| <b>Reference</b> | <b>R/268/19/PL</b>                                                                                                                                                        |
| <b>Proposal</b>  | <b>Demolition of existing garage &amp; store on existing dwelling &amp; erection of 1 no. four-bed chalet style dwelling (re-submission of planning ref: R/72/19/PL).</b> |
| <b>Location</b>  | <b>6 Manor Road Rustington BN16 3QT</b>                                                                                                                                   |

DRAWING No: DS/6MANORNEW/04/REV1

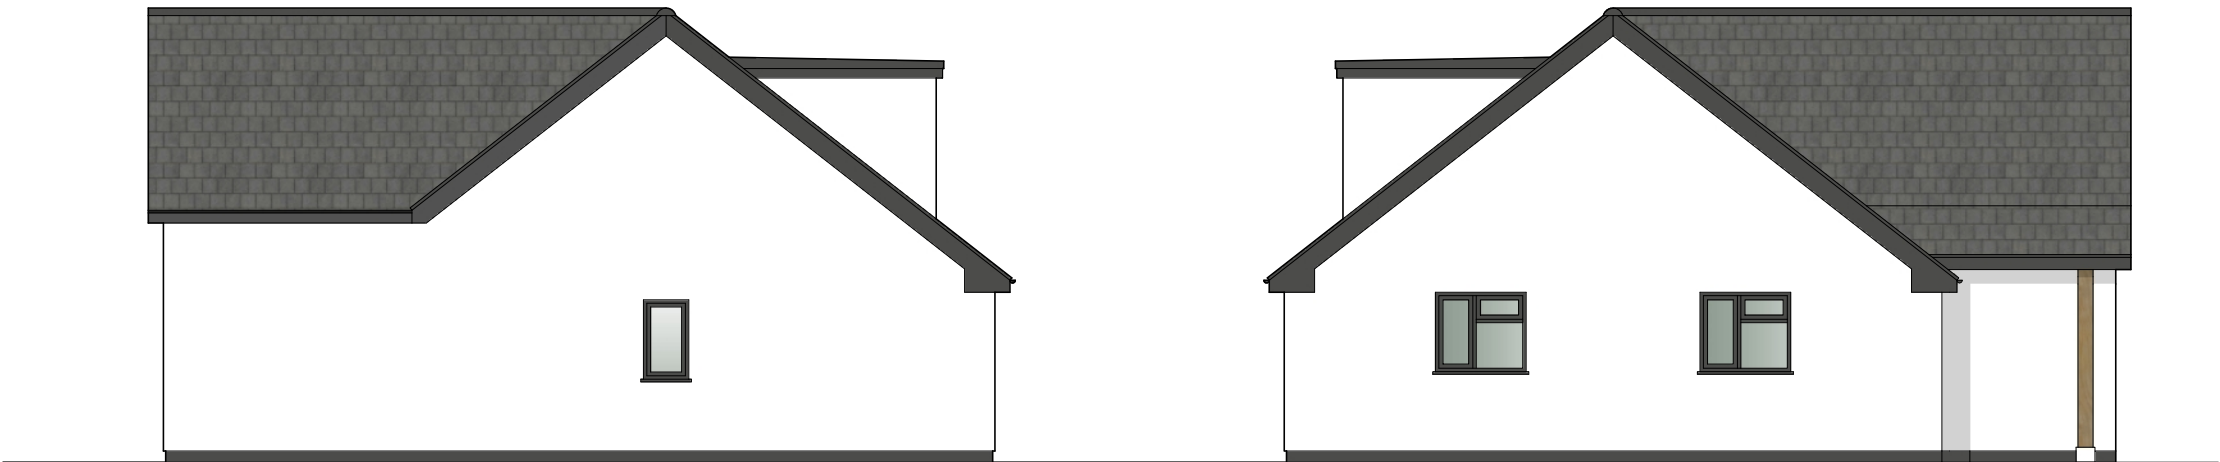
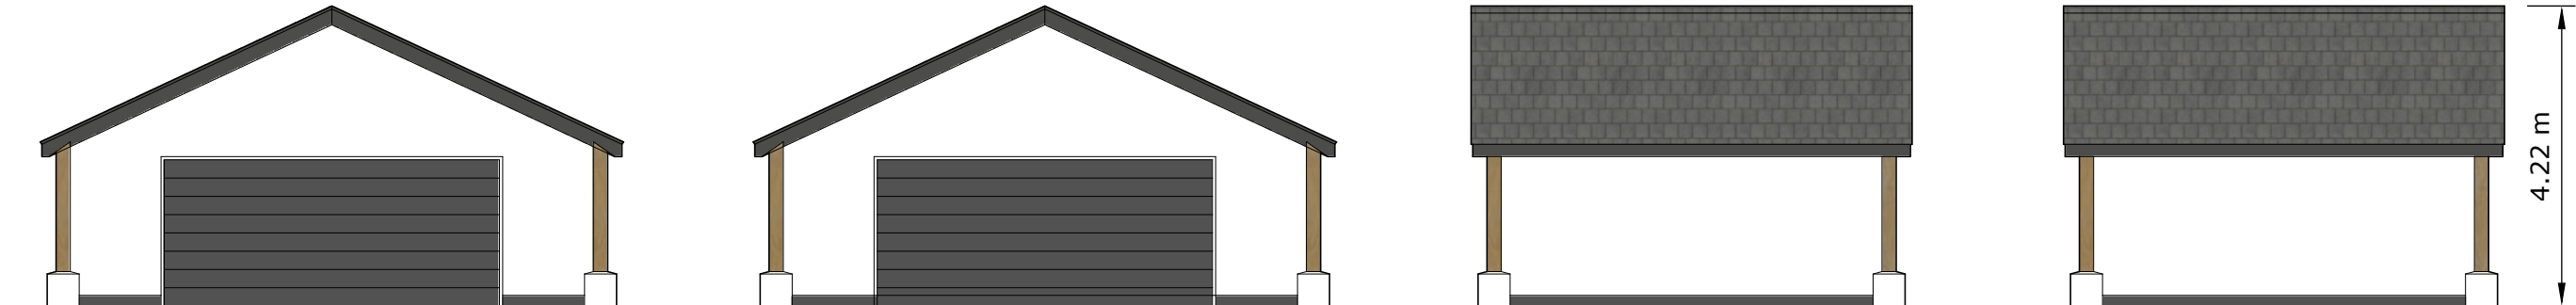
We require that a bat box is installed on the building onsite facing south/south westerly positioned 3-5m above ground.

We would like a bird box to be installed on the new building / and or tree within the garden of the property.
